**Submission – Warragamba Dam Raising Project (SS1-8441)
Regarding Aboriginal Cultural Heritage Assessment**

This submission has been prepared by Dr Paul Irish and Fenella Atkinson of Coast History and Heritage Pty Ltd on behalf of Gundungurra Traditional Custodian Kazan Brown in relation to the proposed Warragamba Dam Raising (SSI-8441). Specifically, it relates to the Aboriginal Cultural Heritage Assessment Report (ACHAR) and supporting documents prepared by Niche Environment & Heritage as part of the Environmental Impact Statement (EIS) for the proposal.

Figure 8-4. Upstream impact area

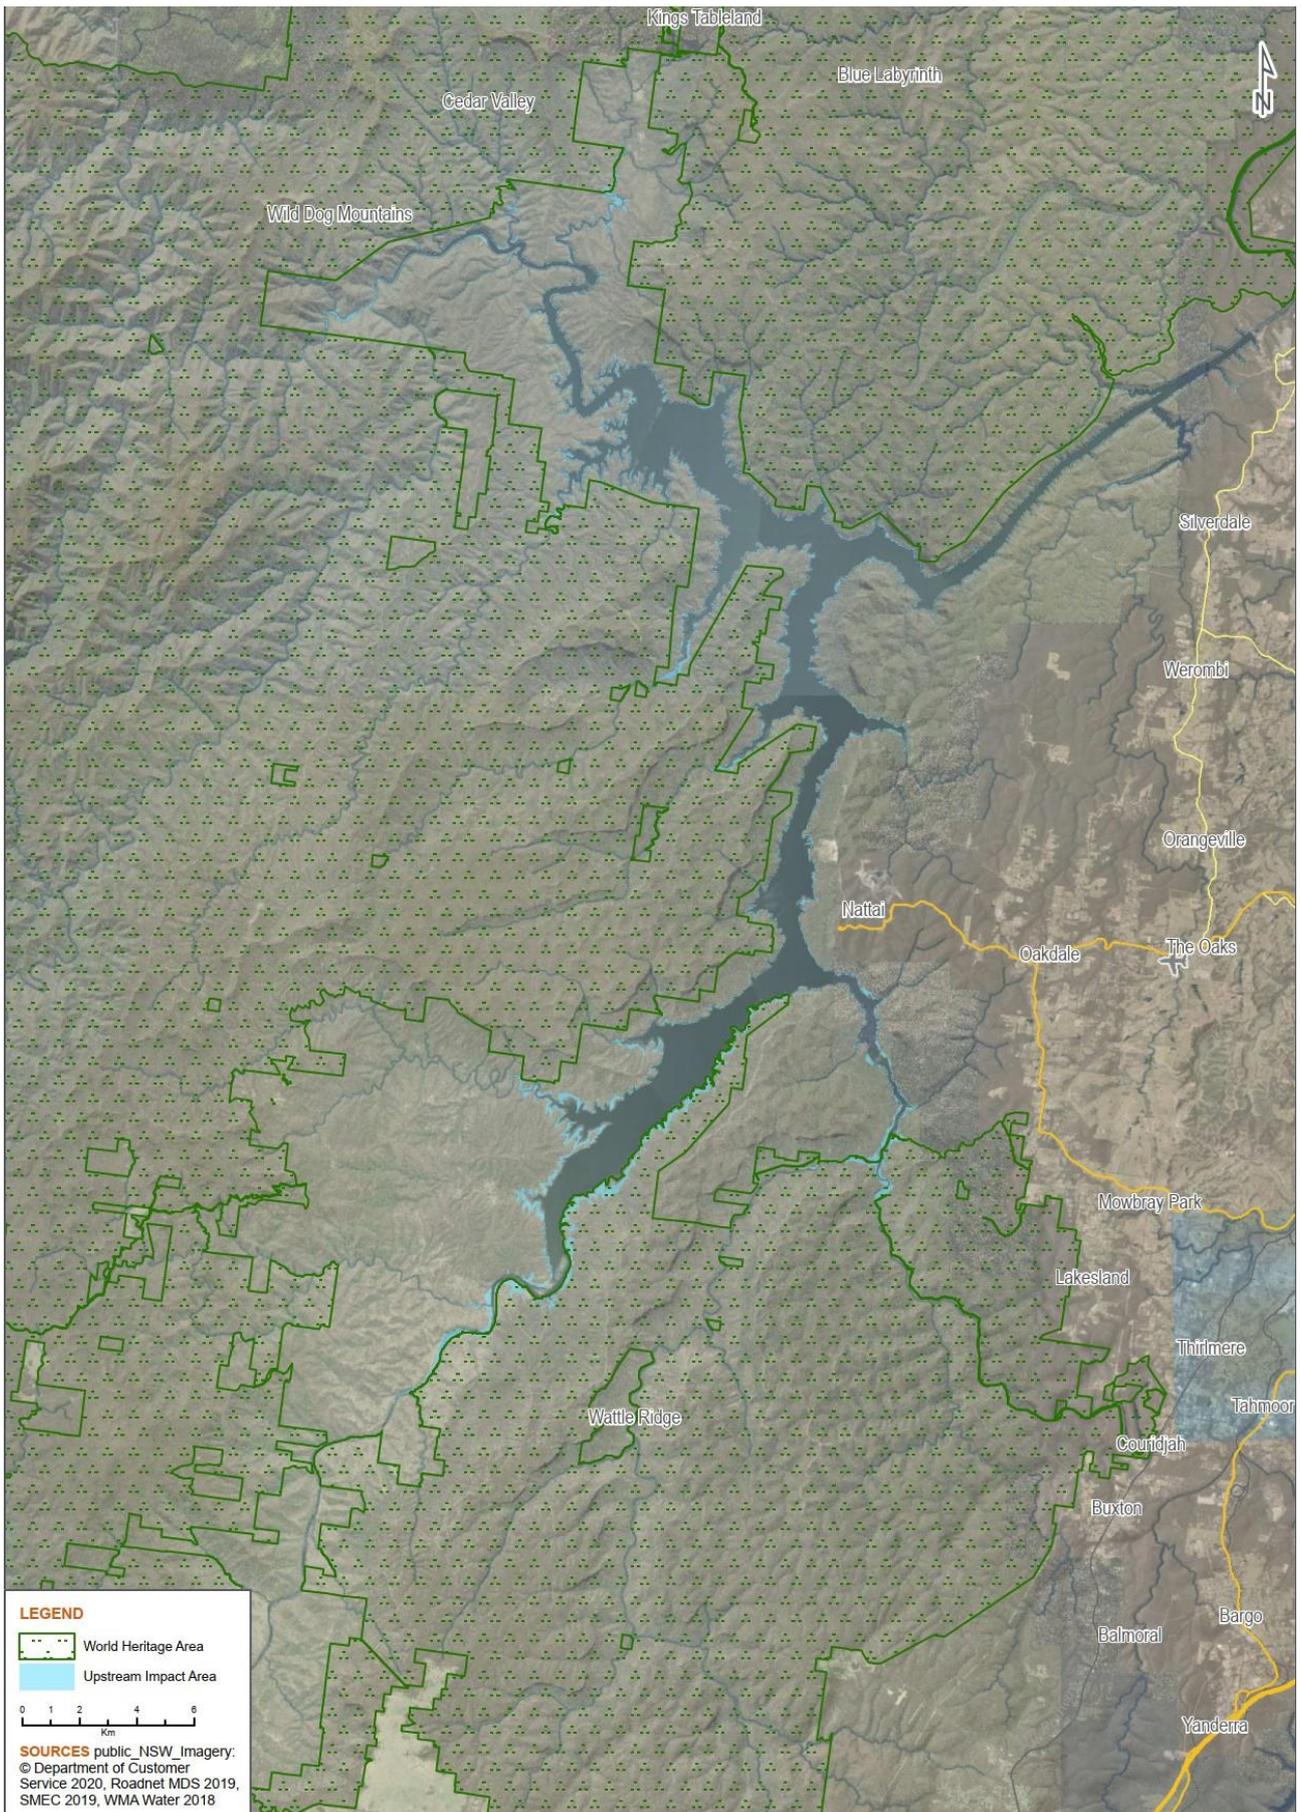
The complex definition of the study area and focus of impact assessment on the Project Upstream Impact Area [PUIA] has been roundly criticised by RAPs and in submissions to the 2019 Legislative Council Select Committee on the Proposal to Raise the Warragamba Dam Wall. We echo those sentiments, in particular because Requirement 3.1(c) states that assessment of all key issues must '*identify, describe and quantify (if possible) the impacts associated with the issue, including the likelihood and consequence (**including worst case scenario**) of the impact (comprehensive risk assessment), and the cumulative impacts*' [our emphasis in bold]. The sample survey of a small portion

of the ‘worst case scenario’ upstream landscape for archaeological sites and without any substantial consideration of the intangible cultural values of this area clearly does not address this requirement.
